July 19, 2017

RE: **10800 Gibson SE (SSTP)**
Grading and Drainage Plan
Engineer's Stamp Date: Signed, undated
Hydrology File: M21D007A1

Based on the information provided in the submittal received on 7/18/17, the Grading and Drainage Plan cannot be approved for grading or paving permit until the following comments are addressed:

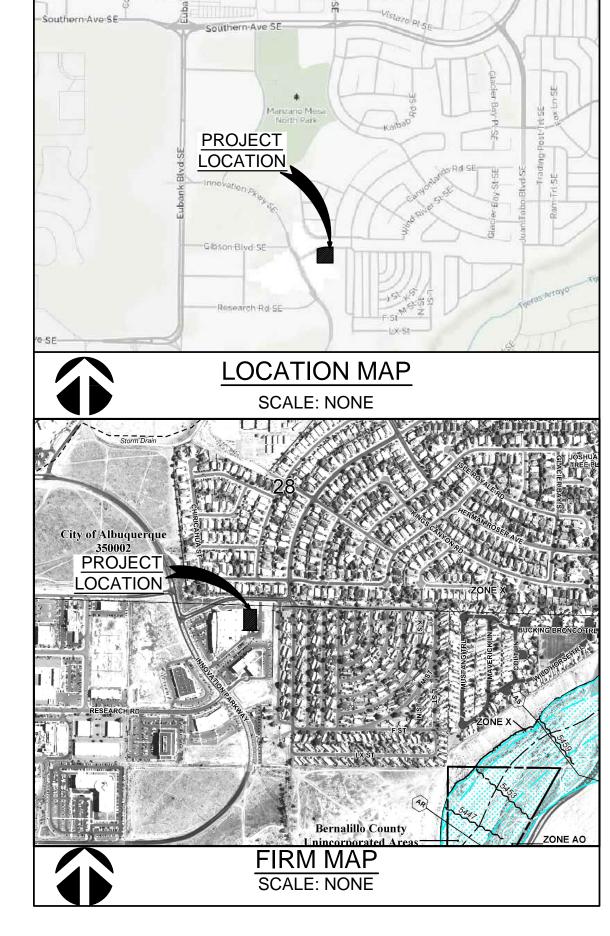
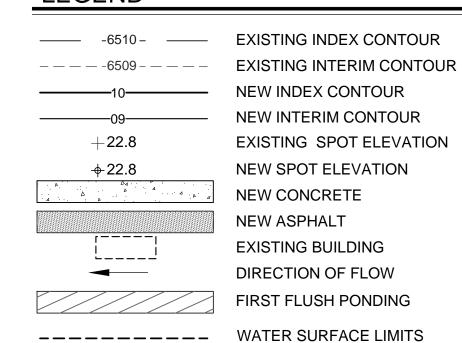
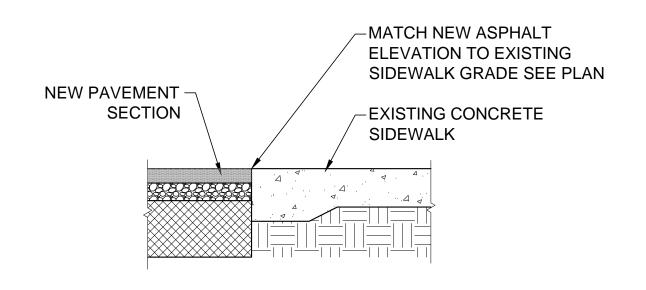
2. First flush volume needs to be determined from: (0.44"-0.10") x impervious area. The required first flush volume for this site will be based on only the new impervious area.

3. Provide the finished floor elevation for the building. The finished floor should be 1' above existing grades.
4. What is the 100yr water surface elevation for the pond and where does it overflow? Ensure the pond overfilling won't affect the adjacent building.

5. Provide additional spot elevations (top of asphalt) and grades for the proposed parking area to ensure the site will be constructed to drain away from the building.

6. Valley gutter is recommended (but not required) along the flowline of the parking area.
7. A private facility drainage covenant is required for the pond (see attached). Once filled out, this document will need to be turned in to Madeline Carruthers (mtafoya@cabq.gov, 4th floor, Plaza del Sol) for signature routing.
8. Date the plan. Hydrology tracks submittals and resubmittals by the Engineer's stamp date.
9. Request paving permit approval on the DTIS when resubmitting, Hydrology can approve for Grading and Paving Permit concurrently for no additional cost.
10. Only one hardcopy (and one pdf) is required for Hydrology submittals.
